Portishead Branch Line (MetroWest Phase 1)

TR040011

9.18 ExA.CWR.D3.V1 – Applicant's responses to Written Representations submitted at Deadline 2

Responses to Additional submissions received at Deadline 2

Drawing
PORTISHEAD STATION CAR PARK
LAYOUT, LANDSCAPING AND NEW
BOULEVARD AND ACCESS PLAN
SHEET 2 OF 3

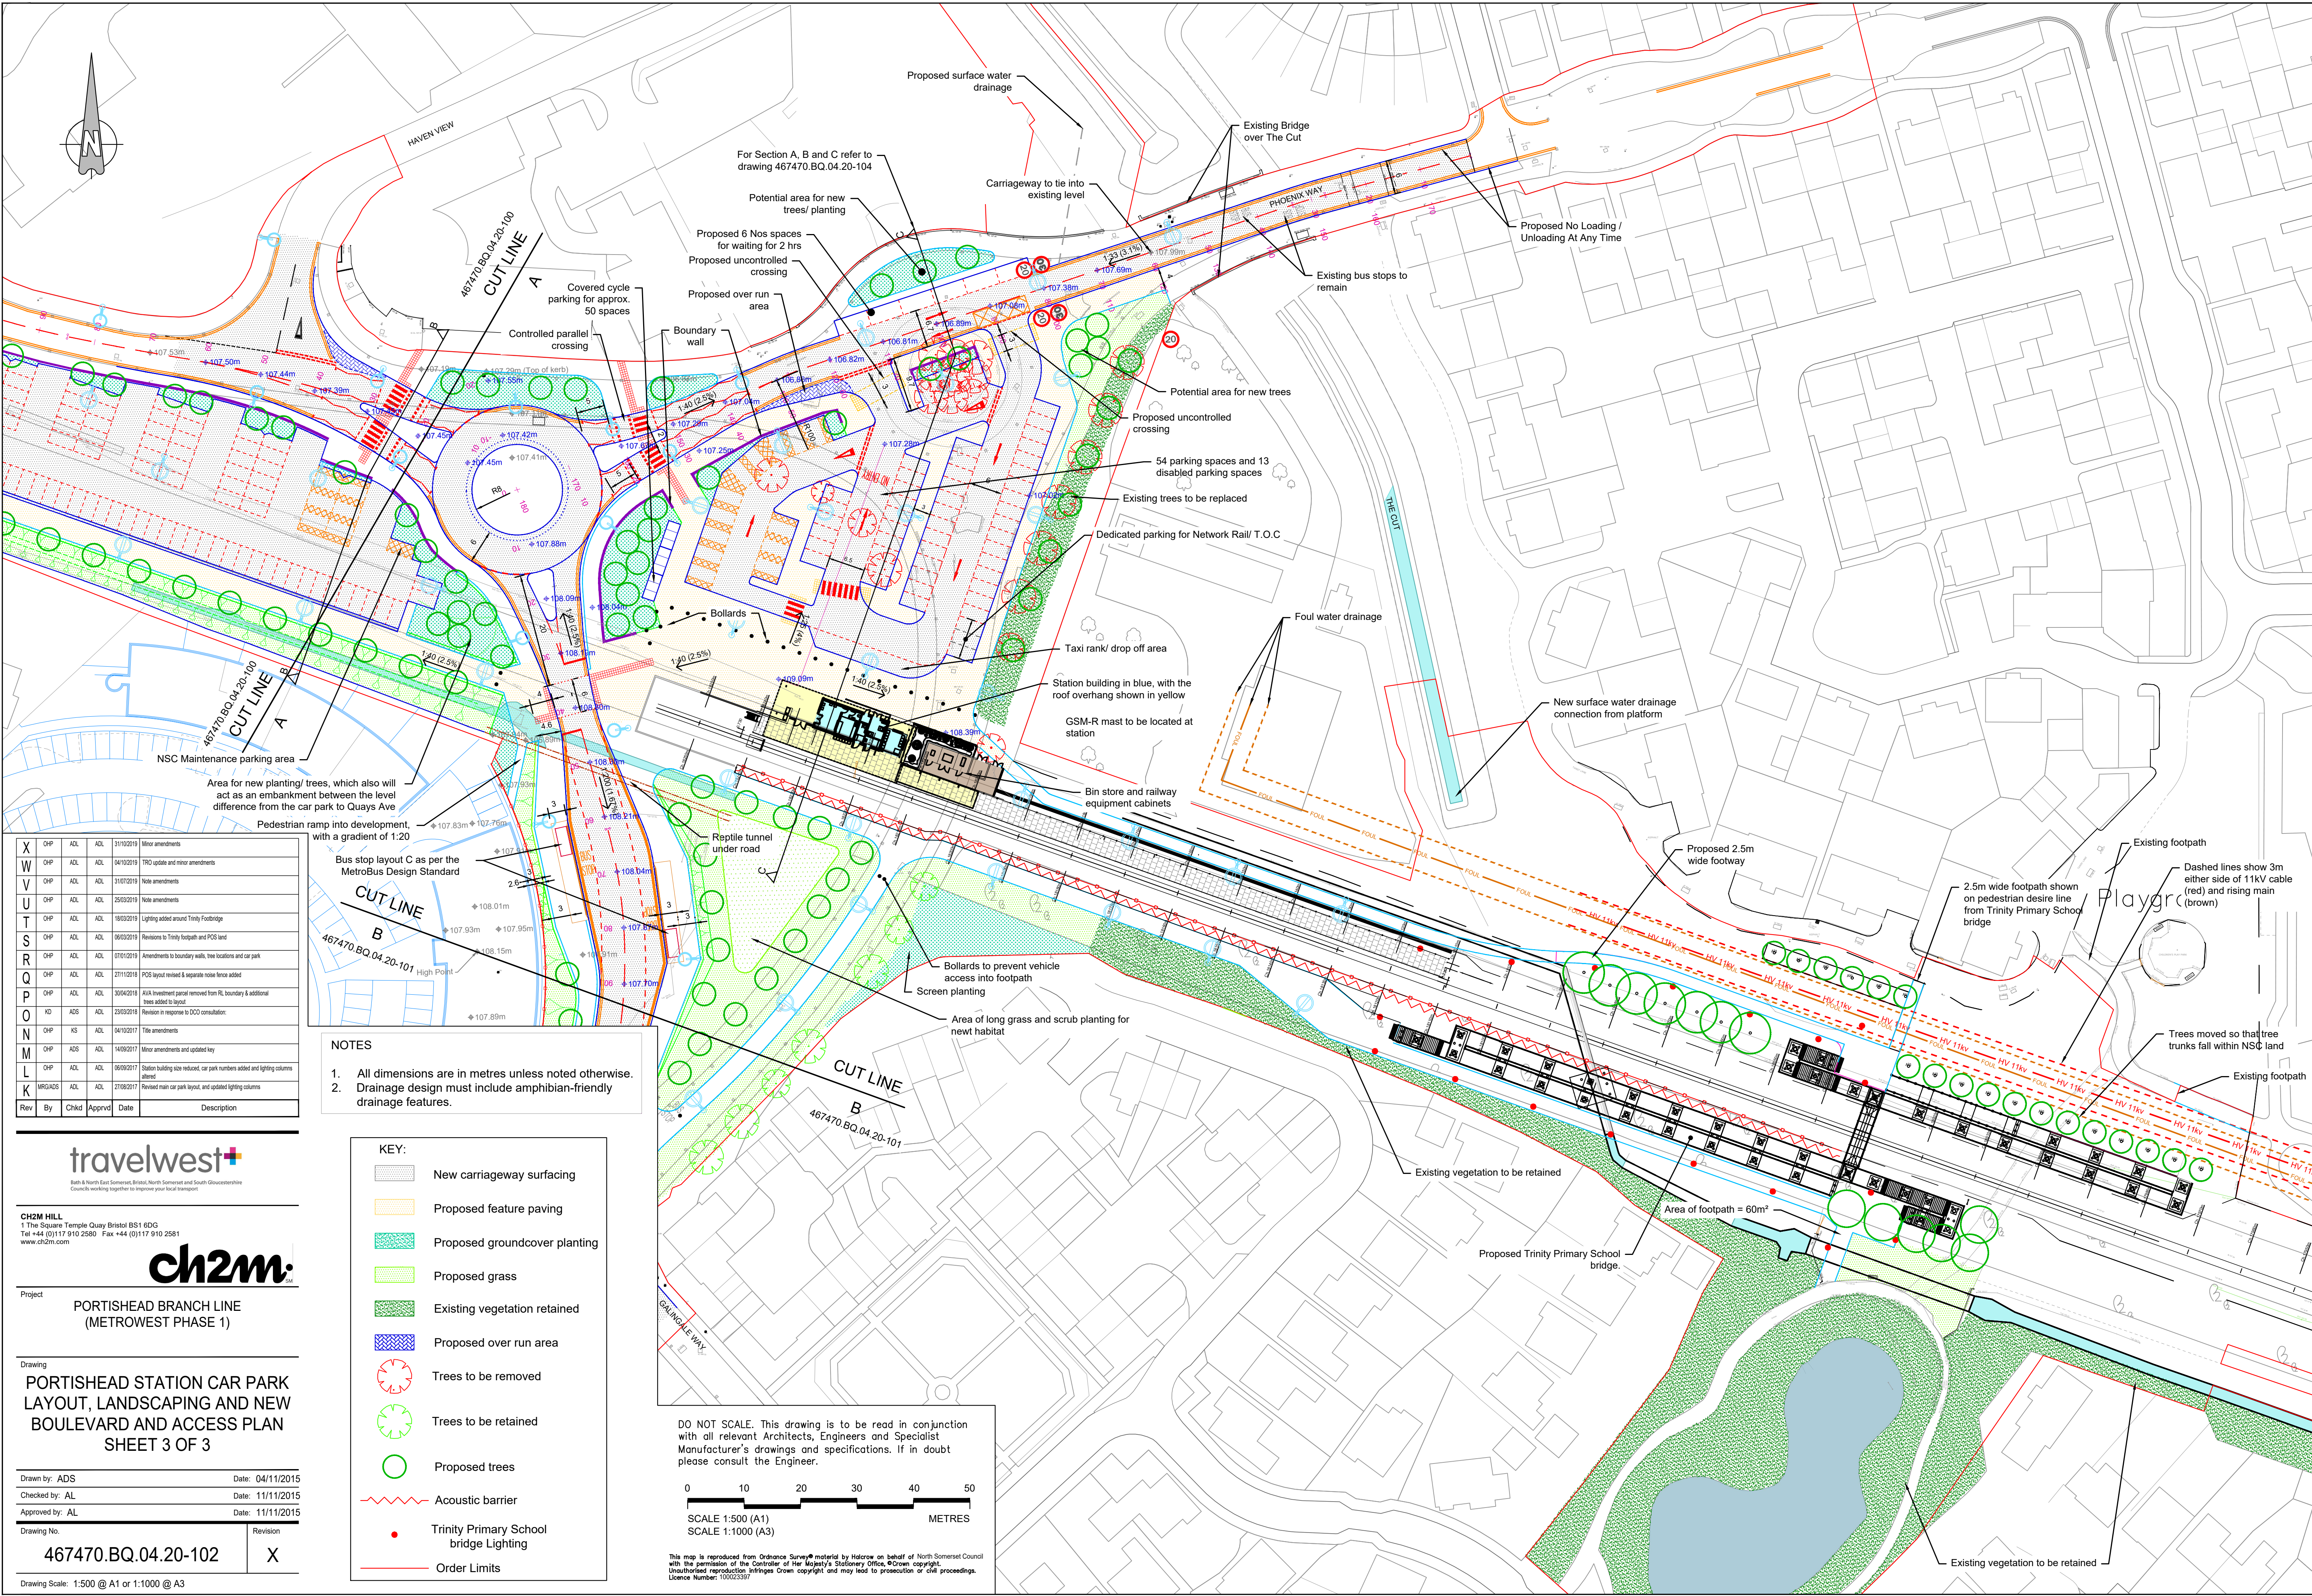
SA-D2-006			<p>Also the footbridge design shows that it has lights that come on whenever someone uses it. This is totally unacceptable as it is proposed to go alongside the full length of the house and garden of two dwellings.</p>	<p>Trinity bridge lighting will be maintained by North Somerset Council, with occupancy detectors also installed to dim the lighting on the bridge and stairs when unoccupied. It is proposed to install handrail lighting on the stairs and ramp which is very directional and reduces overspill into neighbouring properties. There are anti-climb</p>

SA-D2-014			<ul style="list-style-type: none"> •Damage to Aspect – The houses effected will be able to see the bridge from every part of the property and garden where currently there is open sky and green trees. This is negatively impacting the feel of the property that has been built and occupied for the last 20 years. The impact of the train station and proximity to the station is not in question here it is wholly the objection to construction of the bridge. 	<p>Detailed information on the design of Trinity Bridge is shown on the drawings within the document Trinity Bridge Plans (APP-019; DCO Document Reference 2.15 to 2.17).</p> <p>Proposed tree planting has been refined in line with utility constraints and minimises the effects on the open space.</p> <p>The bridge is proposed to be Holly Green in colour (please refer to the legend/notes box on document S051 Trinity Bridge Proposed General Arrangement Plan (APP-019; DCO Document Reference 2.15). However, the final colour for the bridge will be subject to agreement of the LPA through the discharge of Requirement 4 of the dDCO (DCO Document Reference 3.1).</p> <p>The mitigation to reduce the visual impact of the bridge is in part due to the location of the bridge as far away from adjacent properties as possible, as described above.</p> <p>Landscape mitigation in the form of tree planting to provide visual screening is illustrated in the Portishead Station Car Park Layout,</p>

No.	Type / Category	Topic	Issue	Applicant's response
				<p>luminaires on the bridge deck and 5m columns in area on approach to the bridge.</p> <p>Being LED and modern fittings there is very limited upglow, and they are designed to meet environmental E2 guidelines for rural areas (details from GN01-2005 Guidance notes for the reduction of obtrusive light):</p> <p>Sky glow – 2.5%</p> <p>Light trespass into windows pre curfew – 5 lux</p> <p>Light trespass into windows post curfew – 1 lux</p> <p>Source intensity pre curfew – 7.5kcd</p> <p>Source intensity post curfew – 0.5 kcd</p> <p>As this bridge and surrounding areas are not at a station it is considered a public path, hence the lux level instead have an average of 30 lux for the bridge (from BS 5489-1), an average of 10 lux for the walkways and 0.4 uniformity.</p>
SA-D2-007			<p>In summary. This proposed bridge is going to be an expensive structure. It has few benefits and several disadvantages. Thus we would argue that the proposed Trinity Footbridge is not necessary and a enormous waste of money.</p>	See response to SA-D2-004.

No.	Type / Category	Topic	Issue	Applicant's response
				<p>Landscaping and New Boulevard and Access Plan (APP-035; DCO Document Reference 2.38) – see drawing 467470.BQ.04.20-102. The extent of planting is limited by existing underground services, notably the high voltage 11kv cables and the foul sewer.</p> <p>The Trinity Bridge Plans (APP-019; DCO Document Reference 2.15 - 2.17) provides additional information on the proposed landscaping (drawing 2.16). The drawings also show that the lighting on the bridge is contained within the hand-rails to avoid the need for lighting columns (drawing 2.17).</p>
SA-D2-015			In conclusion – the necessity for the bridge does not bear out. The considerable cost of installation and ongoing maintenance of the bridge and the deep impact to the houses surrounding it is not balanced by the need. This is before compensation claims are taken into consideration for the impacted properties.	See response to SA-D2-004
